VICTORIA EMBANKMENT FORESHORE AND BLACKFRIARS BRIDGE FORESHORE APPLICATION STATEMENT

**To support a proposed non-material amendment
to the Thames Water Utilities (Thames Tideway
Tunnel) Order 2014 (as amended)**

Name	Data
Document ref:	2530-TDWAY-TTTUN-990-ZZ-RG-704430
Legacy document ID:	
Document type:	Report
WBS Code:	n/a
Owner:	Roger Bailey
Author:	Liz Wood-Griffiths
Keywords:

Document Information
Application for Development Consent
 Extent of loss of listed river wall
 Sheet 2 of 2
 Book of plans - section 19
 DCO-PP-17X-BLABF-190023 - Rev 1
 May 2020

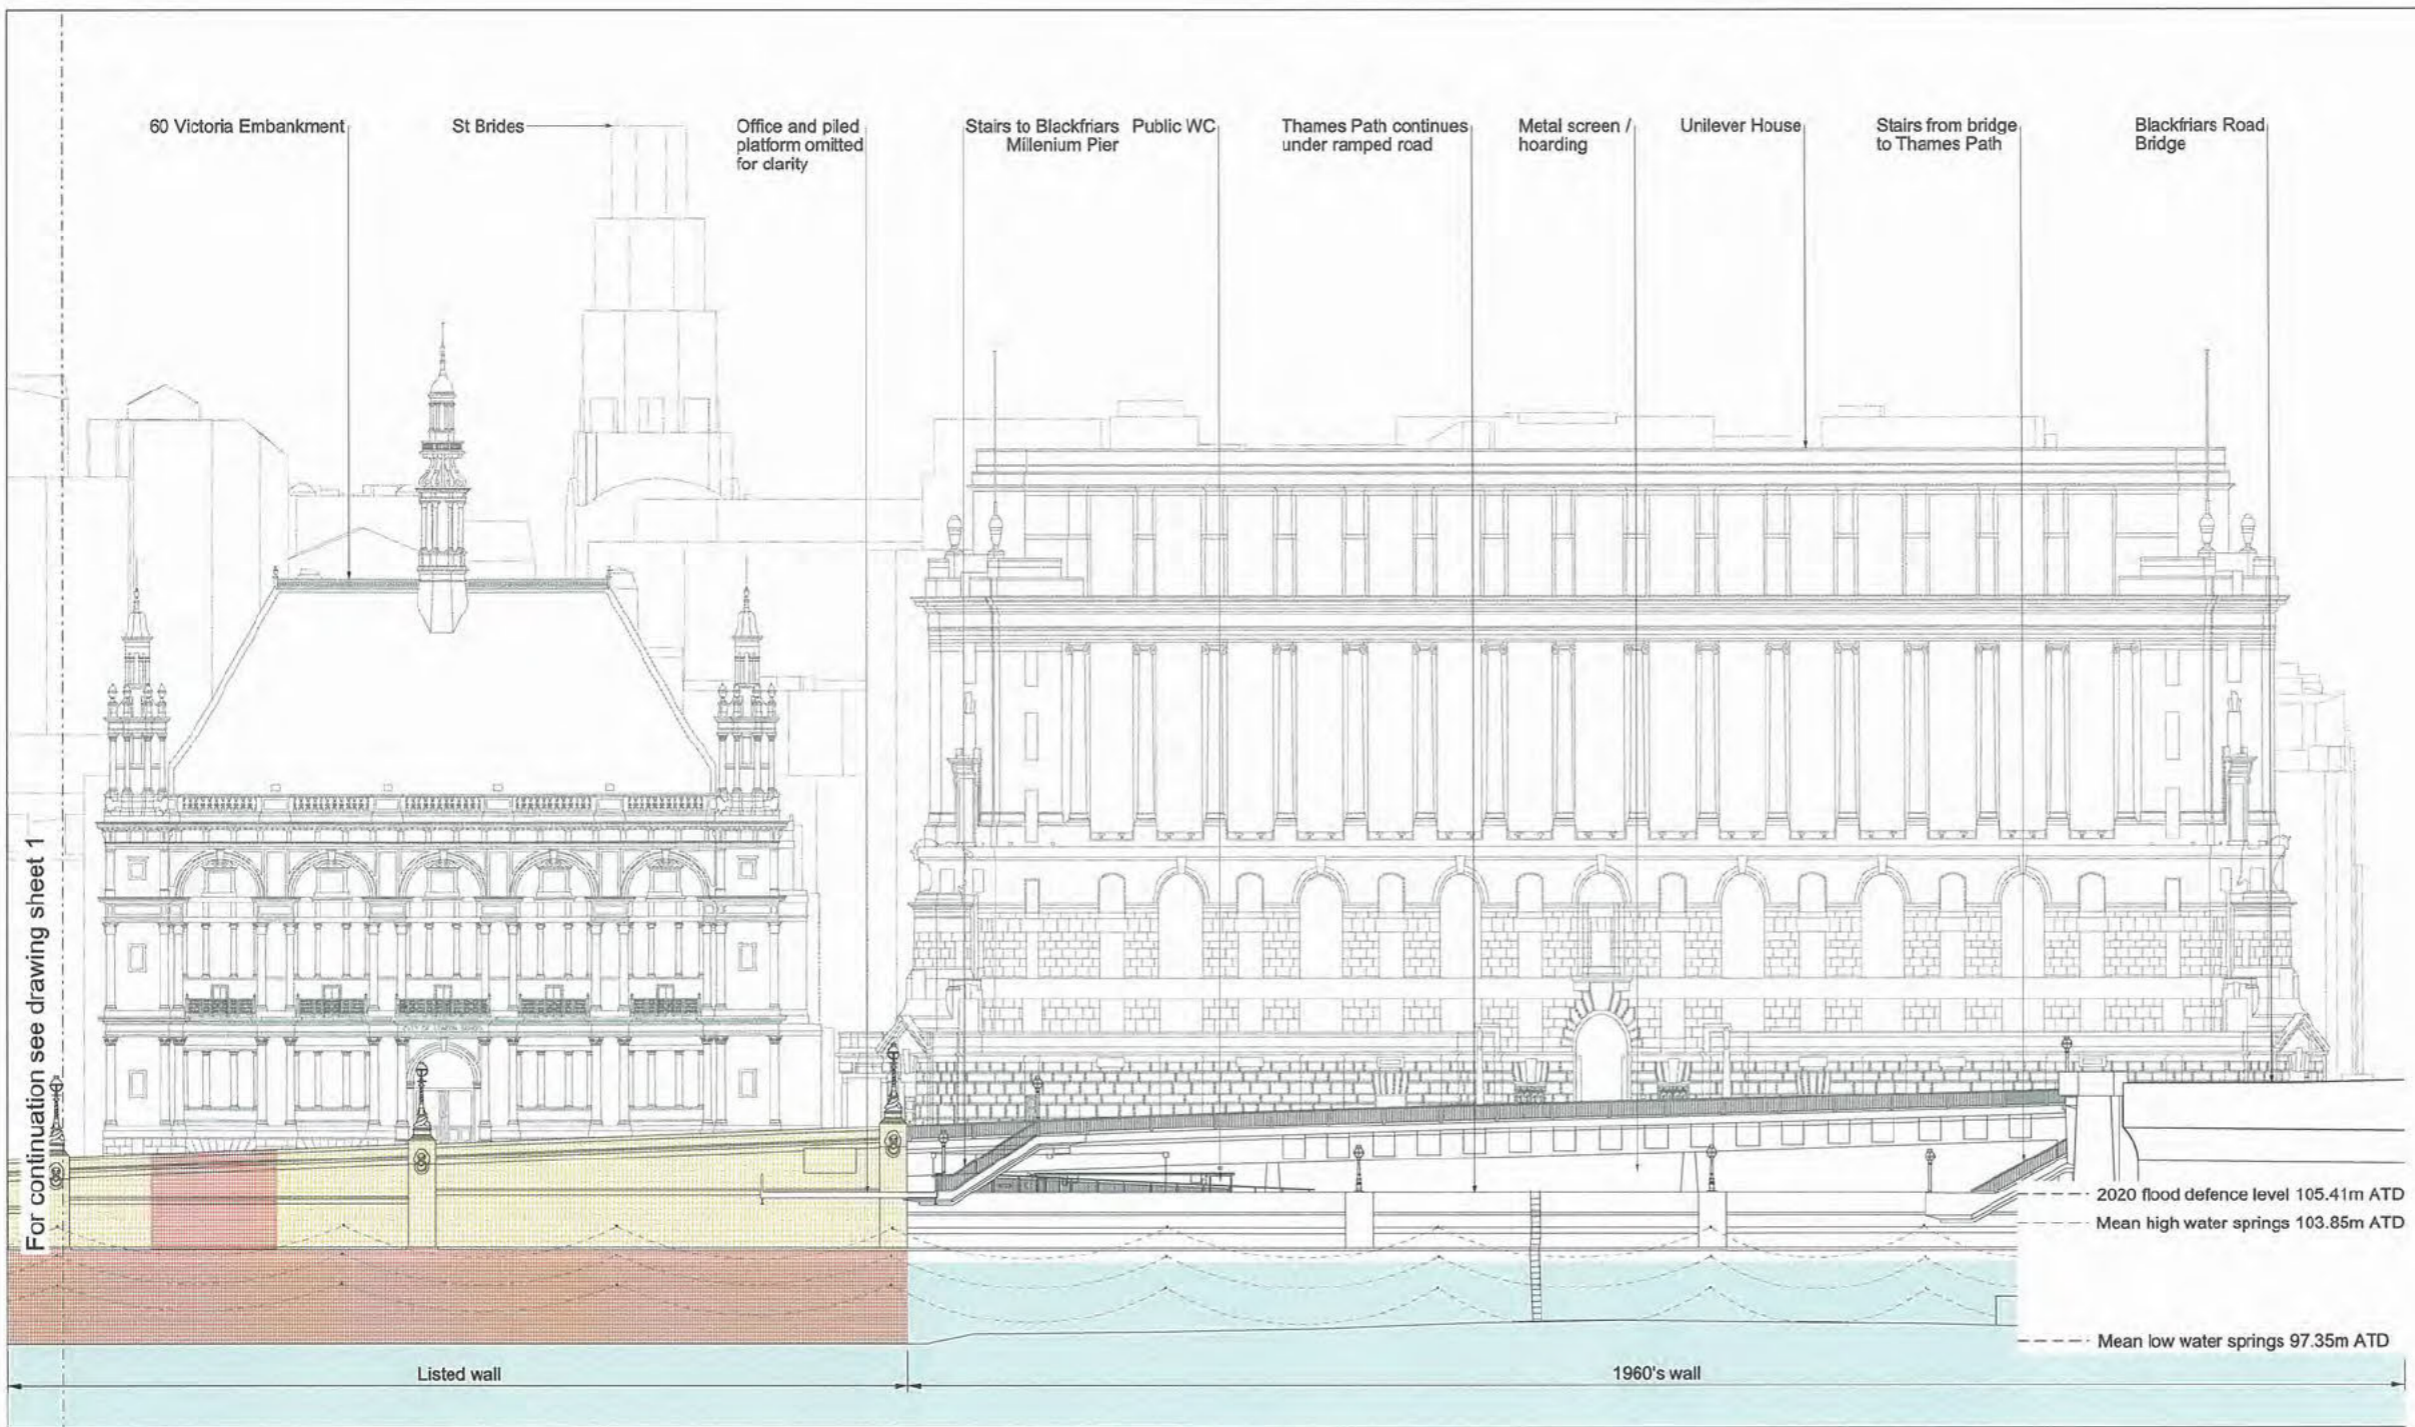
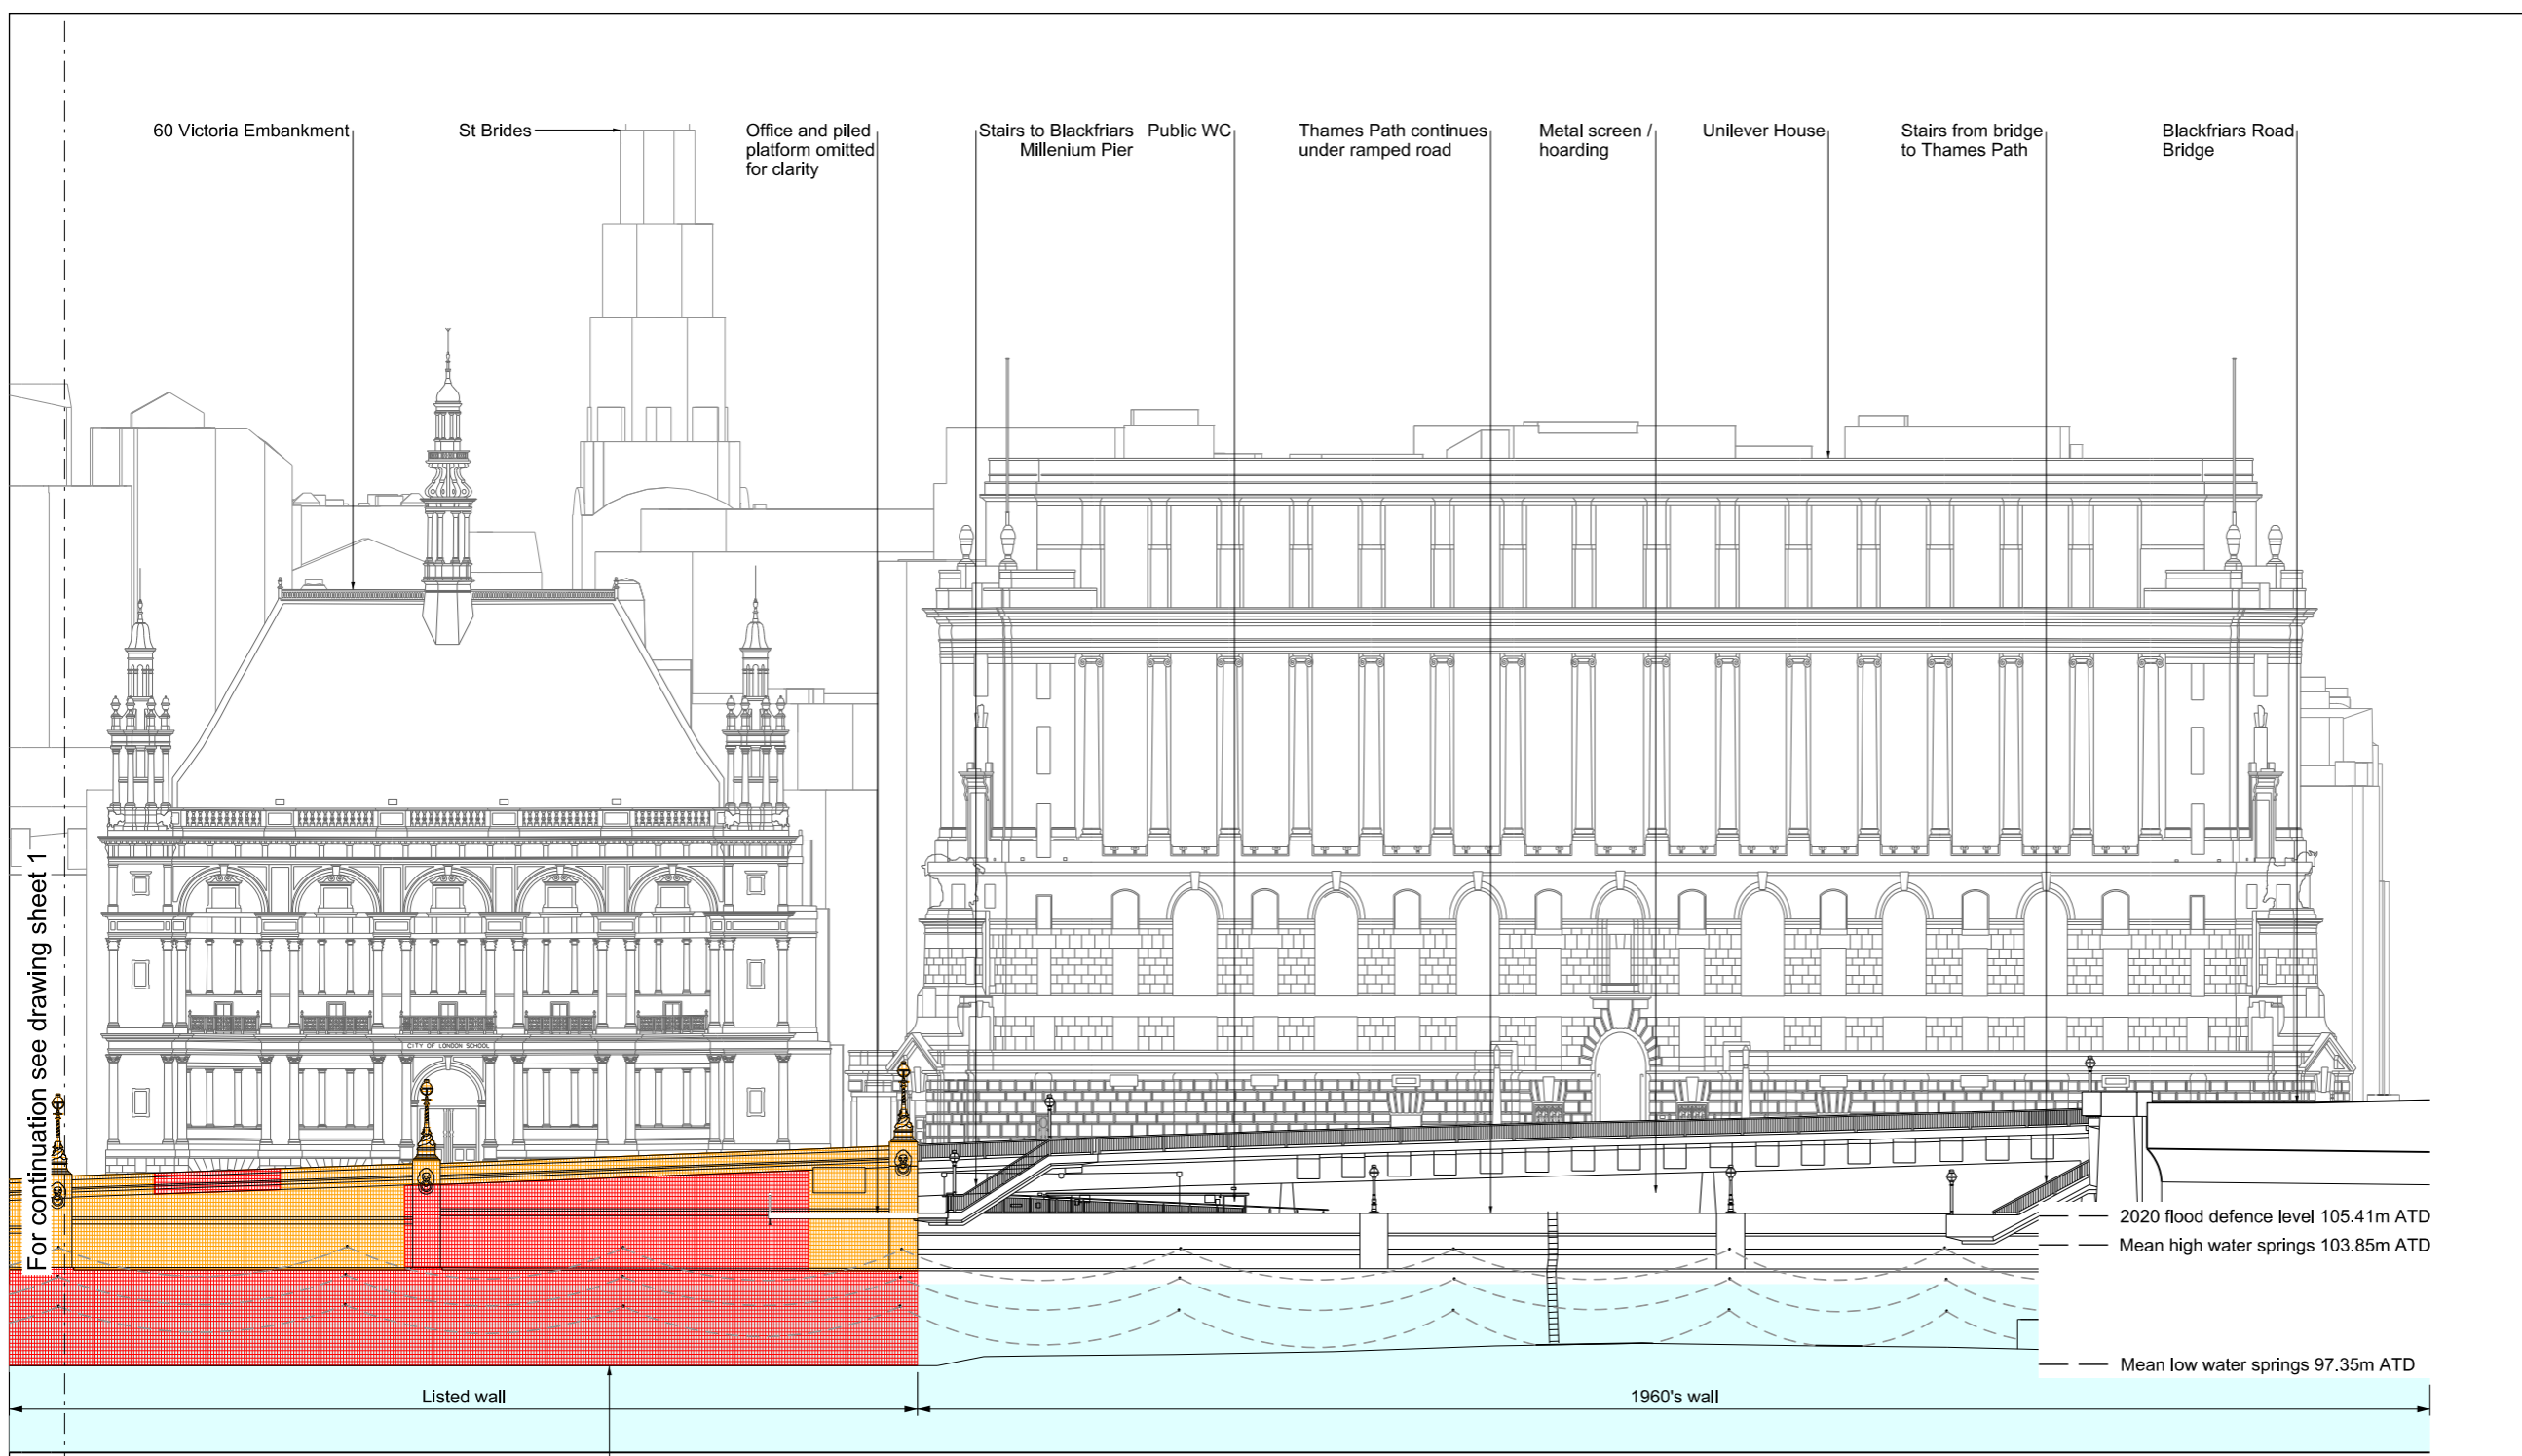
- 3.2.12 The Extent of loss of the listed river wall plans for the Blackfriars site show the extent of loss authorised under the DCO. As currently drawn, the extent of loss of listed river wall drawing DCO-PP-17X-BLABF-190023 incorrectly shows the location for the permanent loss of the listed structure associated with the flow

diversion of the Low Level Sewer No. 1. An amendment to drawing DCO-PP-17X-BLABF-190023 is therefore required to authorise the permanent loss of the listed river wall in the location where these works will take place.

- 3.2.13 It is also proposed to add an informative note to the Extent of loss of listed river wall drawings for the BLABF site (drawings DCO-PP-17X-BLABF-190022-rev 1 and DCO-PP-17X-BLABF-190023). The base of the river wall at BLABF is not usually exposed at low tide and the approved drawings do not show the toe of the embankment wall. The informative note will make it clear that the permanent loss of the listed river wall authorised under the DCO extends to the toe of the river wall.
